**From:** Contact Centre (CRM) <contact@ribblevalley.gov.uk>  
**Sent:** 19 April 2022 08:44  
**To:** Planning  
**Subject:** Planning Application Comments - 3/2022/0315

**Planning Application Reference No.:** 3/2022/0315

**Address of Development:** Land at Preston Road Ribchester PR3 3XL

**BOADICEA Park**  
 Construction Management Plan

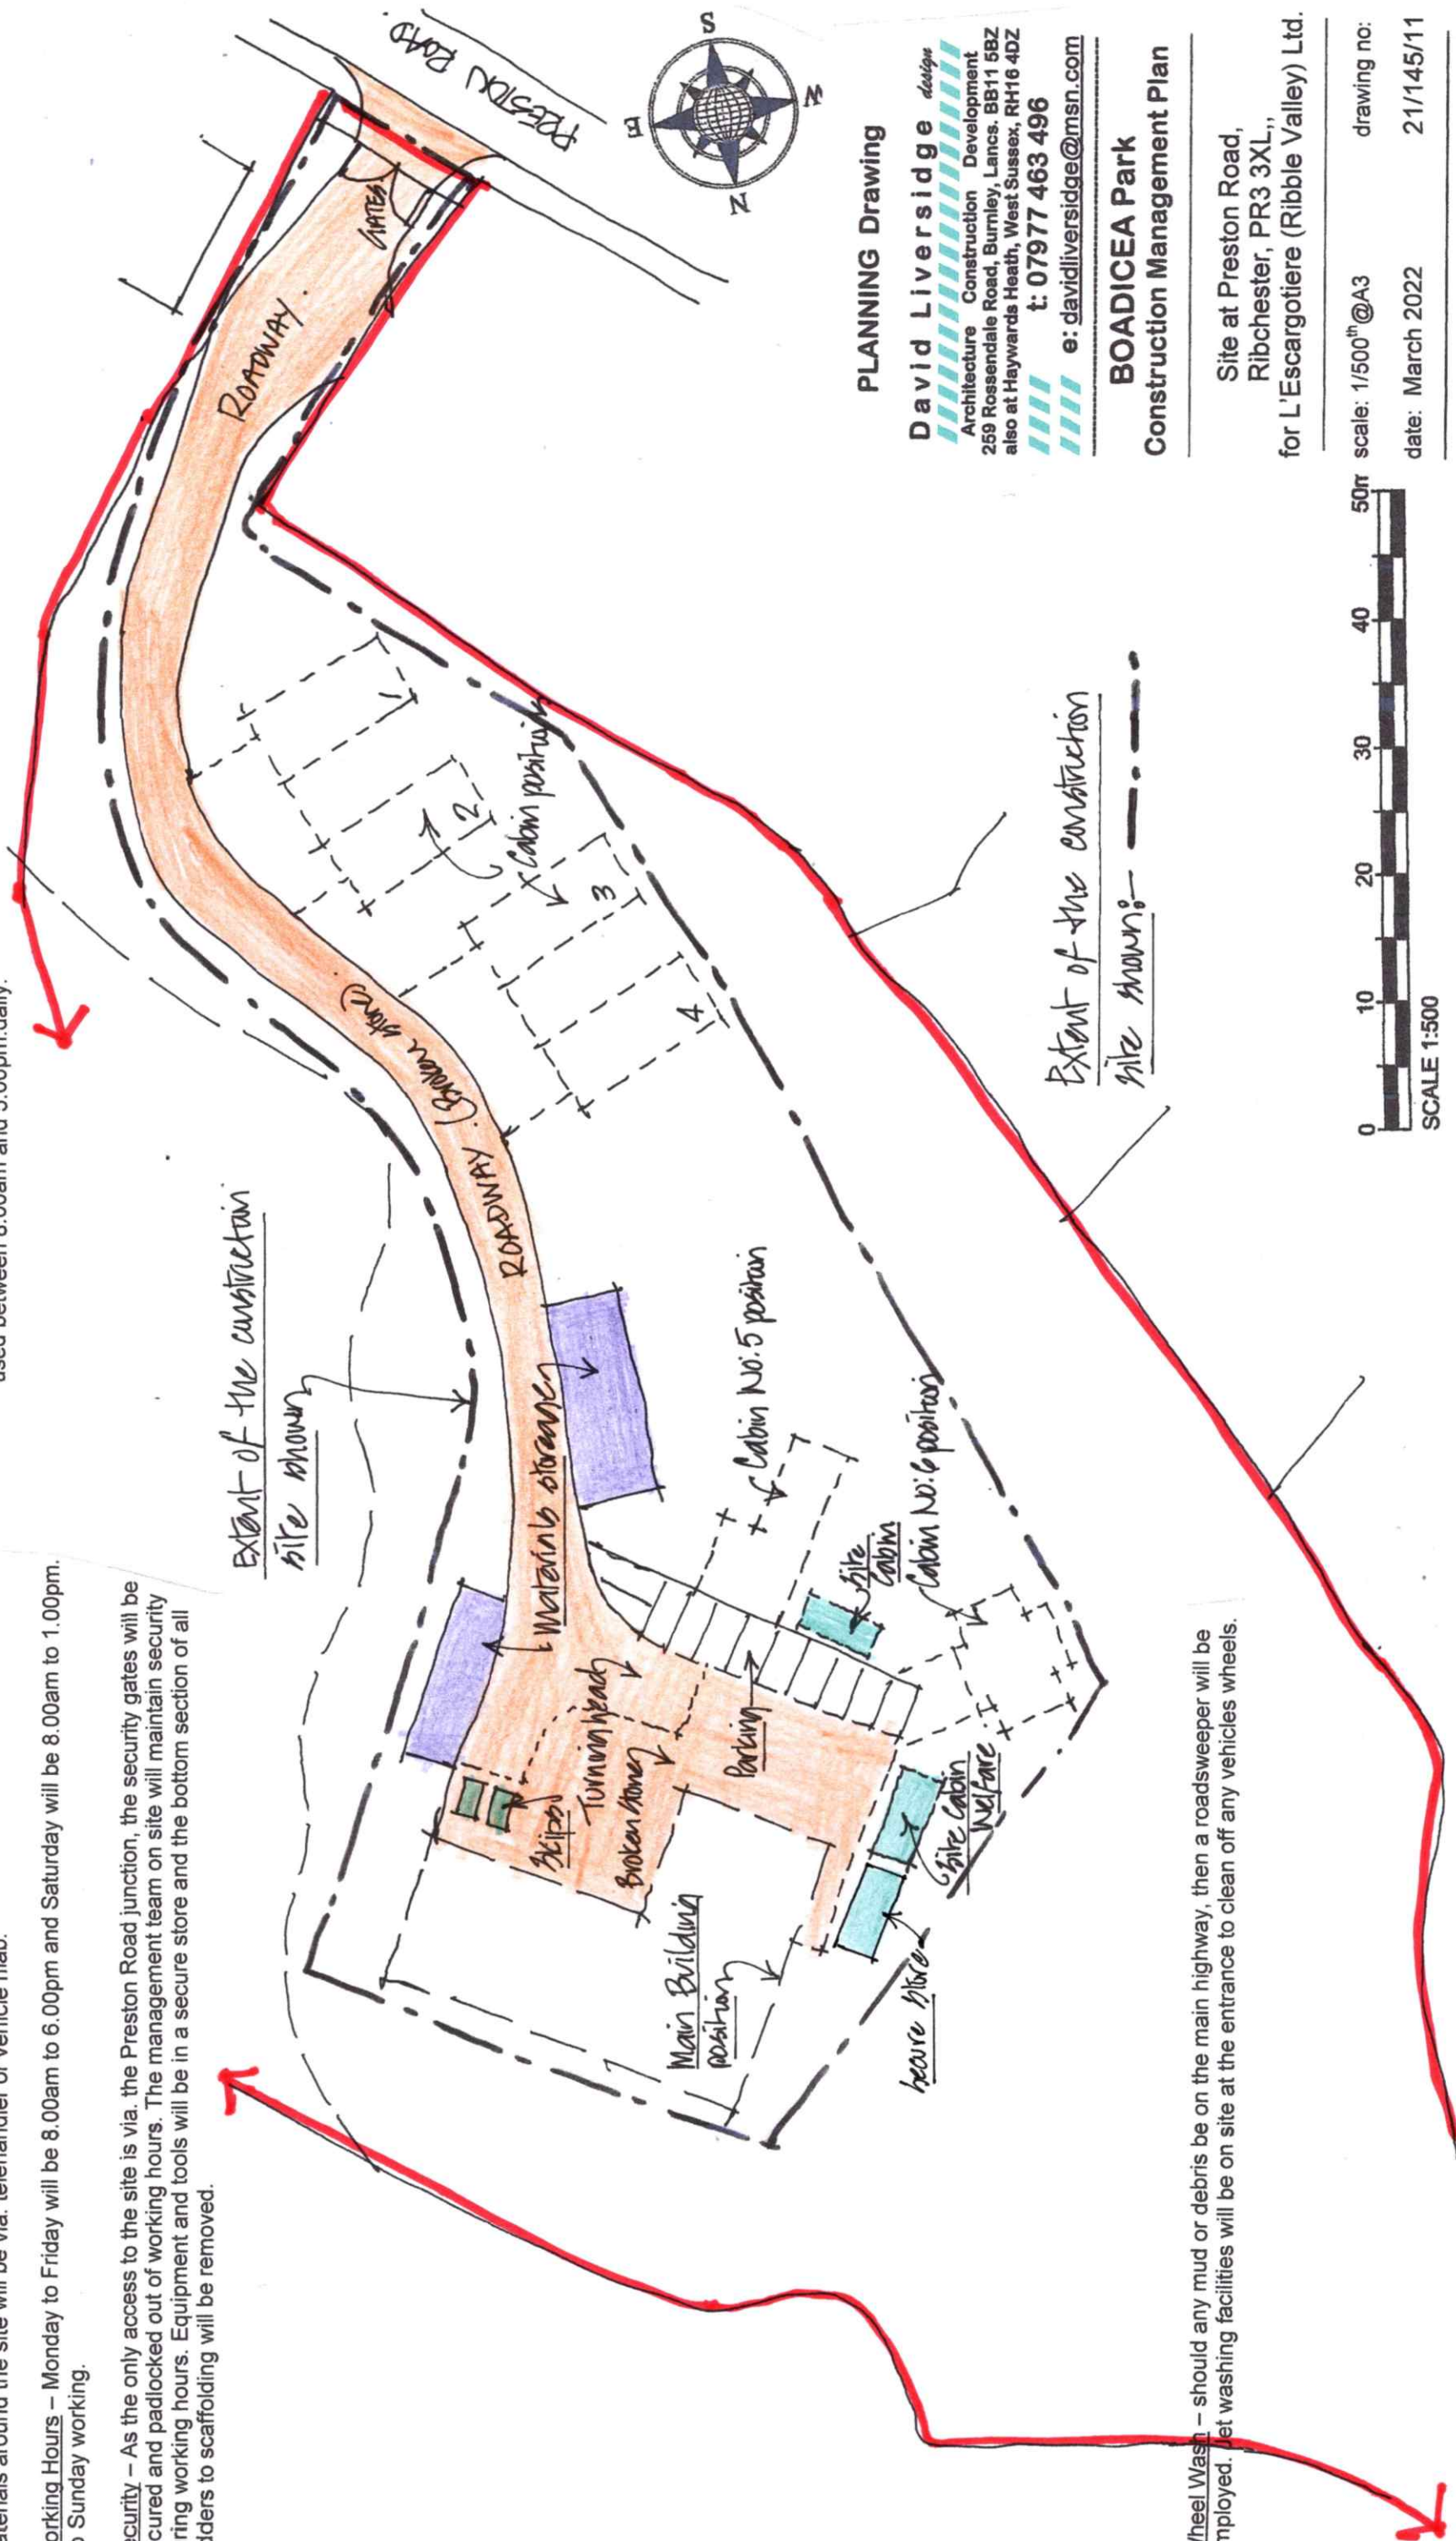
Given the level of heavy plant activity and volume of construction traffic entering the site, it is critical for the impact to be minimised on local residents in terms of safety, noise, and disruption. I am therefore very concerned that variation has been requested in respect of condition 14.
